Replacement of 6 No. windows in communal hallway from single glazed in wood frames to double glazed PVCu.

The Swallows St Catherines Road Littlehampton

Thank you for your internet representation made on 30th September 2019 which has been recorded as '**an objection**' with the comments as follows:

FLATS 1 - 6 EXISTING WINDOWS

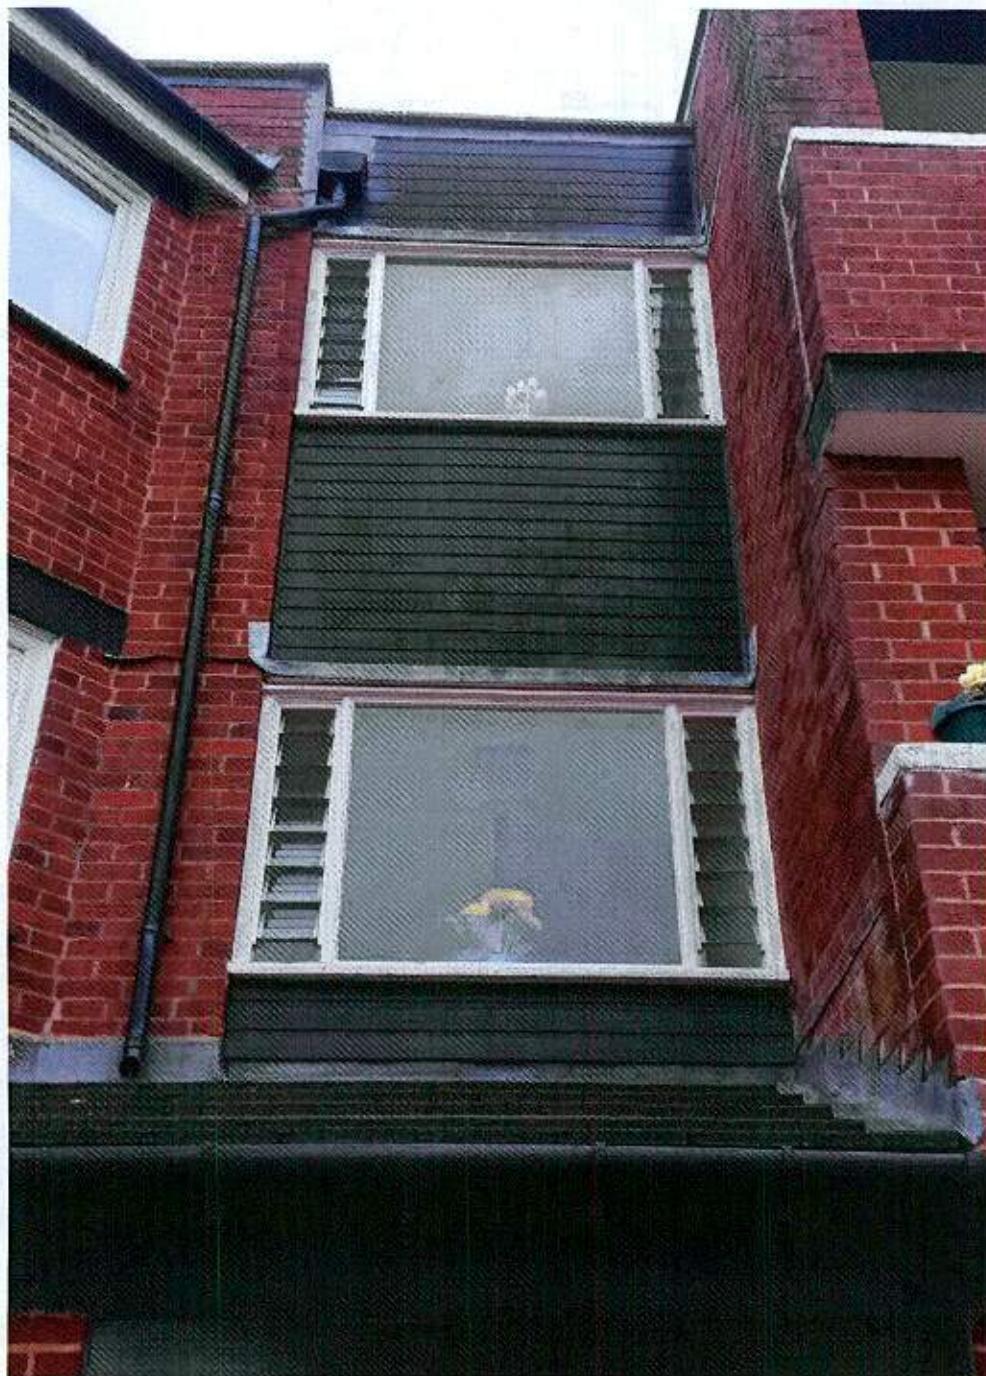
*I have always admired the design of this building because, although dating to the early 1970's, it is extremely well proportioned and finely detailed.
It makes a positive contribution to the Area of Character and occupies a very prominent location opposite Caffyn's Field.
The existing windows, through their frame patterns and proportions, are sympathetic with the particular design of the building.
The introduction of the proposed pvcu windows through their frame pattern, standard appearance and use of fanlights (non exist in the elevations) will materially detract from the appearance of the building.
Any replacement windows need to be of a more sympathetic design and proportion with appropriate frame patterns, widths and profiles. It may be that powder coated aluminium windows could better achieve this.*
